# CITY OF ALBUQUERQUE

**Re: Santa Fe Tow – Armando Beltran, 8000 Jacs Road,  
Traffic Circulation Layout  
Architect's Stamp undated (D16-D002A2)**

**Re: Santa Fe Tow – Armando Beltran, 8000 Jacs Road,  
Traffic Circulation Layout  
Architect's Stamp dated 03-02-11 (D16-D002A2)**

**A-2**

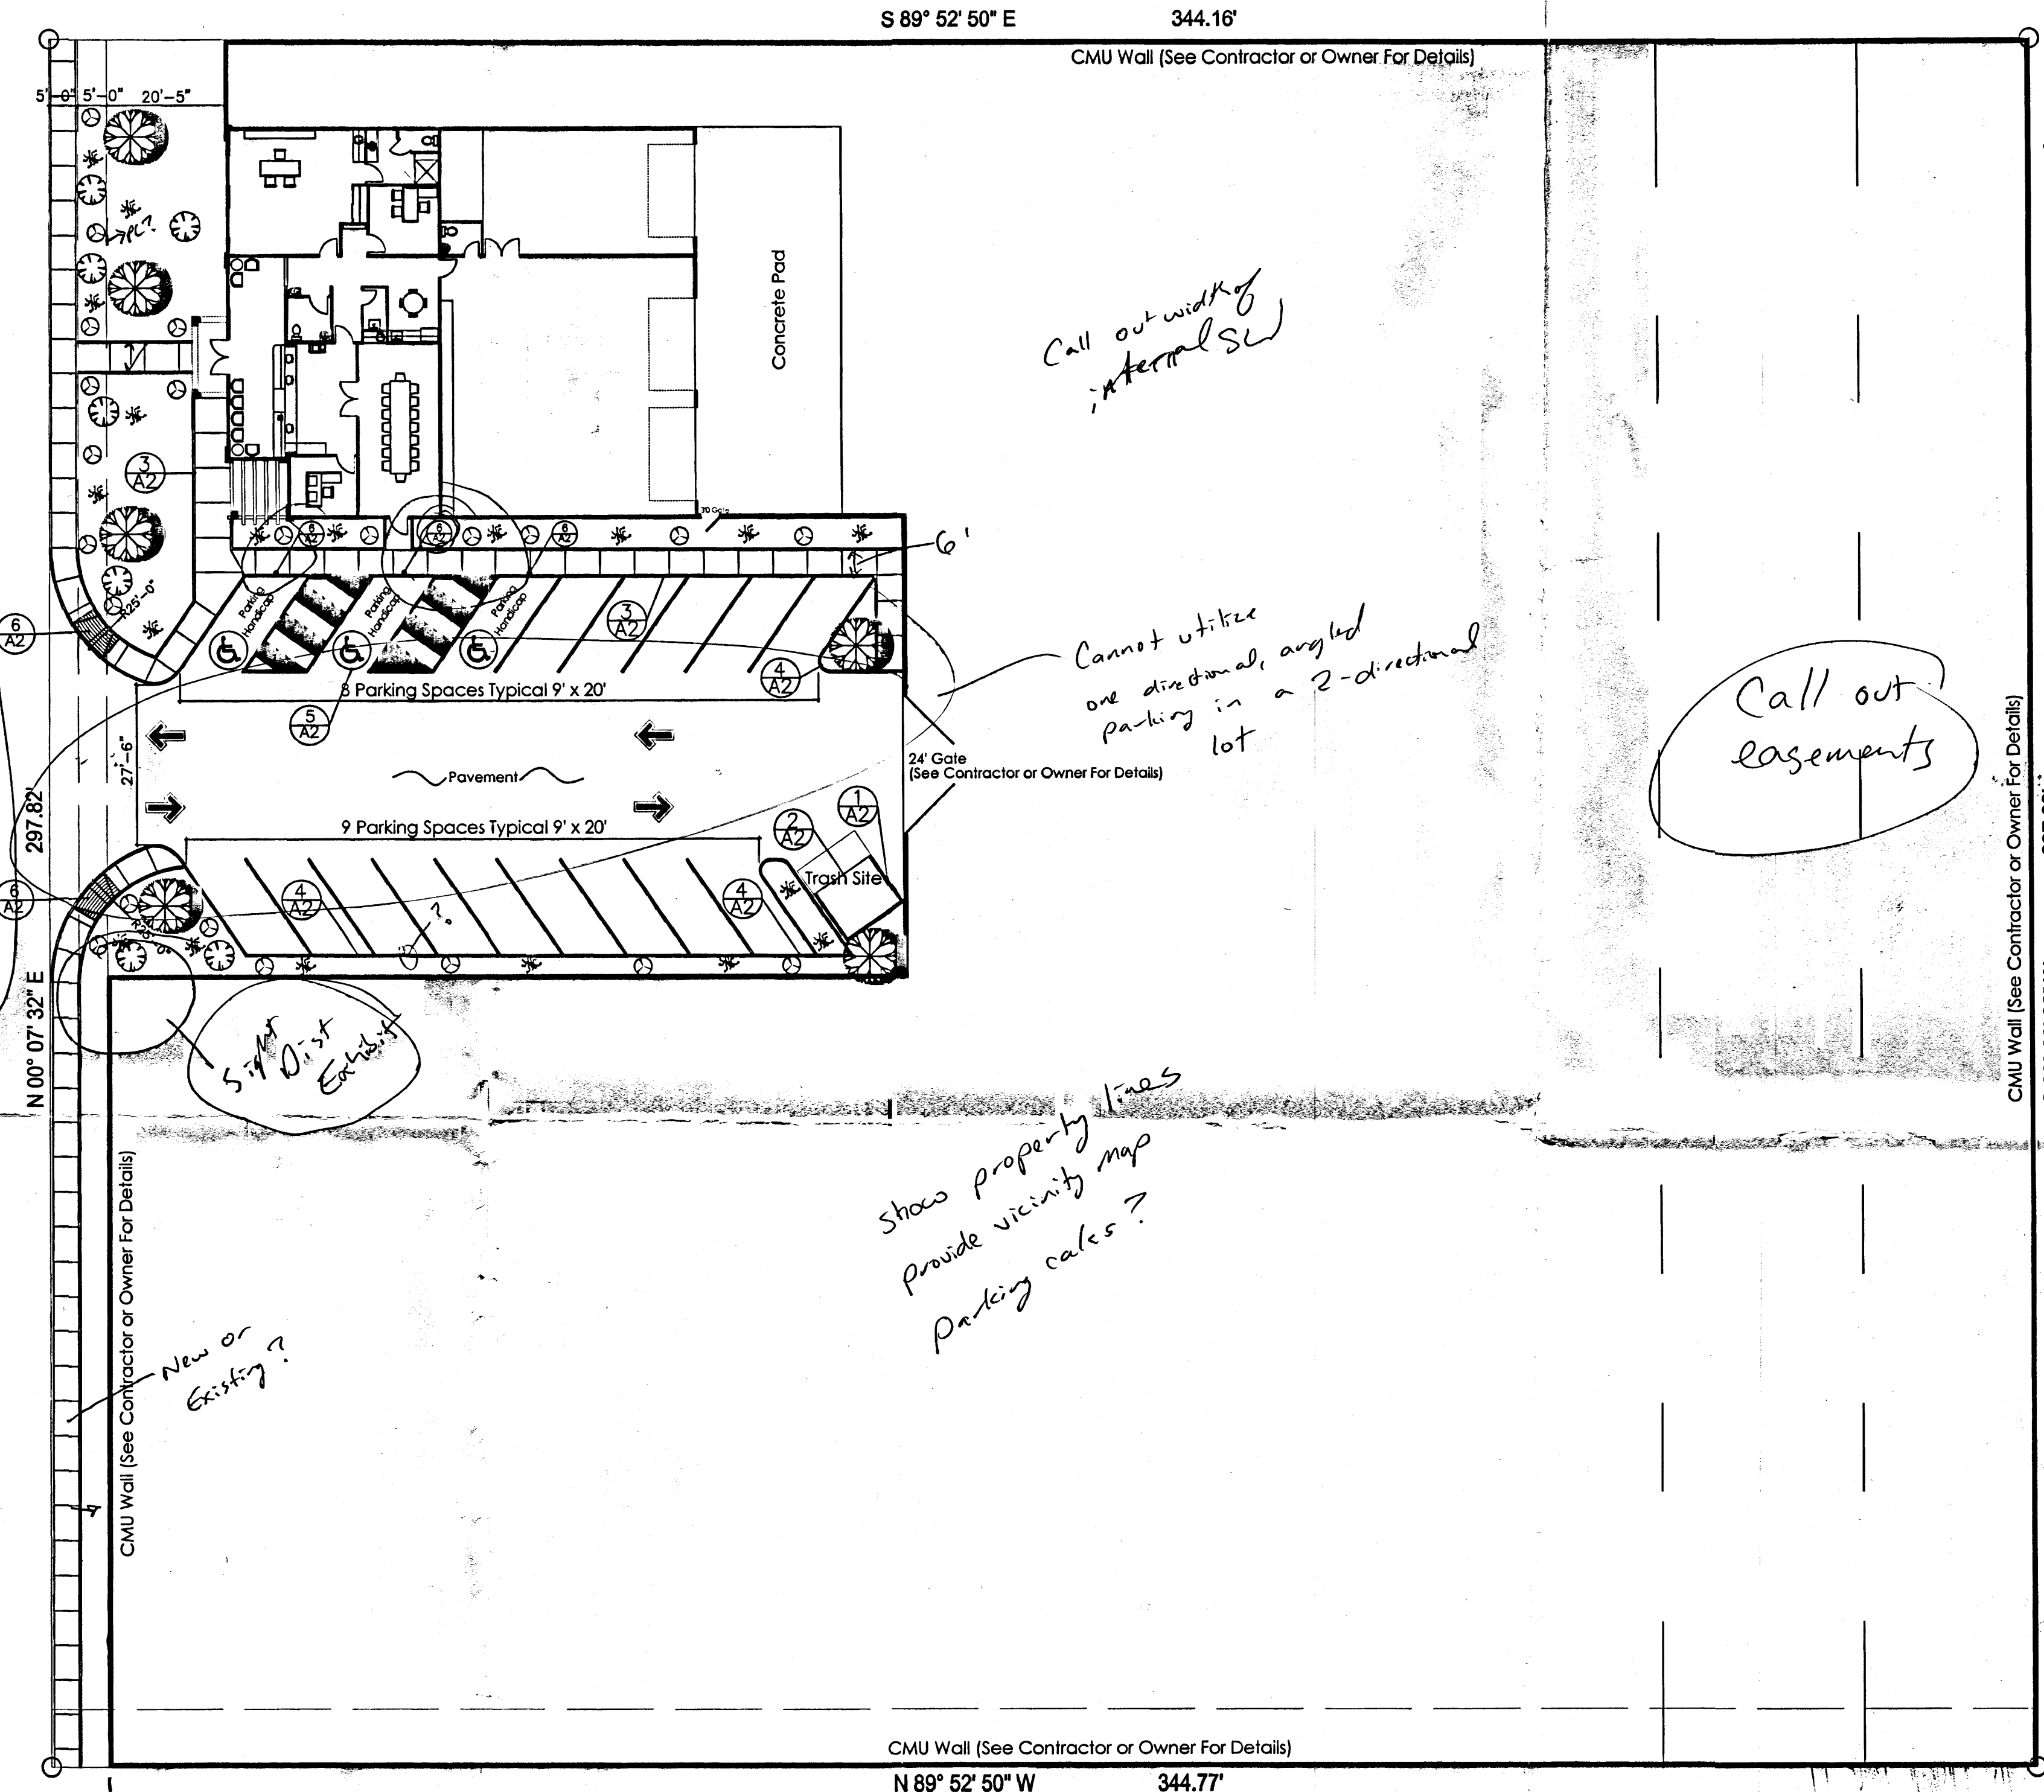
1. Angled parking stalls are only acceptable for one-directional parking areas.
- ✓ 2. This site is clearly designed for two-directional traffic; therefore, angled parking is not acceptable.

- ✓ 3. The property line must be clearly shown on the plan.
- ✓ 4. Provide a legend defining all linetypes.
- ✓ 5. Clearly show and define all easements located on the lot.

- ✓ 6. The traffic circulation layout must be stamped, signed, and dated by an engineer or architect licensed in the state of New Mexico.
- ✓ 7. All ramps located on Jacs Lane must have truncated domes.

- ✓ 8. Label the street on the plan.
- ✓ 9. Please show a vicinity map.
- ✓ 10. List the number of parking spaces required by the zoning code as well as the proposed number of parking spaces.

- ✓ 11. List radii for all curves shown; for passenger vehicles, the minimum end island radius is 15 feet.
- ✓ 12. Define width of all sidewalk. All internal sidewalk must be a minimum of 6 feet wide.

- ✓ 13. Please place the proposed sidewalk at the property line, not the back of curb.
- ✓ 14. The proposed CMU wall may interfere with the sight distance of the entrance. Please provide a sight distance exhibit (see the *Development Process Manual*, Chapter 23, Section 6, Part B.12).

15. Show the limits of asphalt; will the area beyond the gate be paved? If not, a header curb should be installed to protect the asphalt.

16. A detail is provided for the handicapped ramp; this type of ramp is not appropriate for the sidewalk adjacent to the handicapped parking stalls. A new detail must be provided.

17. Please build the ramp in Jacs Lane to City of Albuquerque Standard Specification 2441.

18. Clearly define the 6-foot wide, ADA accessible pathway from Jacs Lane to the building.

19. Clearly define the 6-foot wide, ADA accessible pathway from the handicapped parking stalls to the building.

1. The parking calculations provided indicate that 18 parking spaces are required; why are only 16 parking spaces provided?
2. All text must be a minimum of 0.1" high.
3. Is the sidewalk flush with the pavement along the parking stalls? Please clarify.
4. A ramp is shown west of the handicapped parking; what is the purpose of this ramp?
5. A 6-foot wide, ADA accessible pedestrian pathway is required from the public sidewalk to the building. Please clarify how this will be accomplished. Note that the rise for any ramp run shall be 30 inches maximum, ramps shall have landings at the top and bottom of each ramp run, and handrails are required on ramp runs with a rise greater than 6 inches (Sections 405.6, 405.7, and 505.1, *Americans with Disabilities Act and Architectural Barriers Act Accessibility Guidelines*, United States Access Board, Jul 23, 2004).
